**Consultation Response from Mark Berry KC,
Highways Development Management**

2023/90956 rear of, 1, Sparks Road, Oakes, Huddersfield, HD3 4BX

Erection of 5 dwellings

Date Responded: 25-9-2023.

3. Proposed Site Layout
Scale 1:500

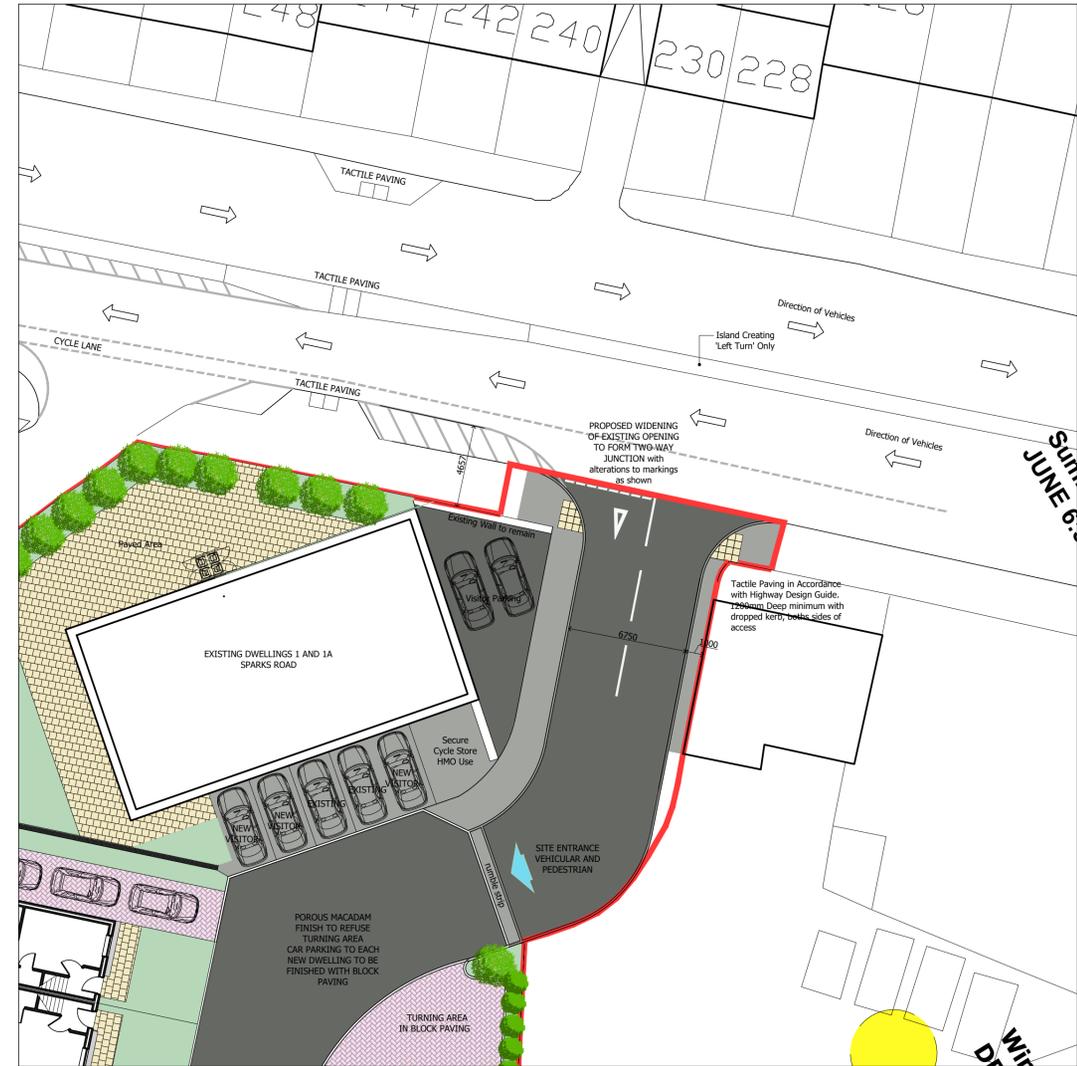
The applicants have provided plan number 22216-01-rev C (Existing and Proposed Site Plans) which show the access widened to 6.75m with a 2.0m with footway to one side and the number of visitor parking spaces increased.

Highways Development Management would recommend that the proposed footway should be re-positioned on the opposite side of the proposed access. This would better separate pedestrian from the existing commercial business, pedestrian would not need to use a footway that the traffic associated with the commercial business would drive across.
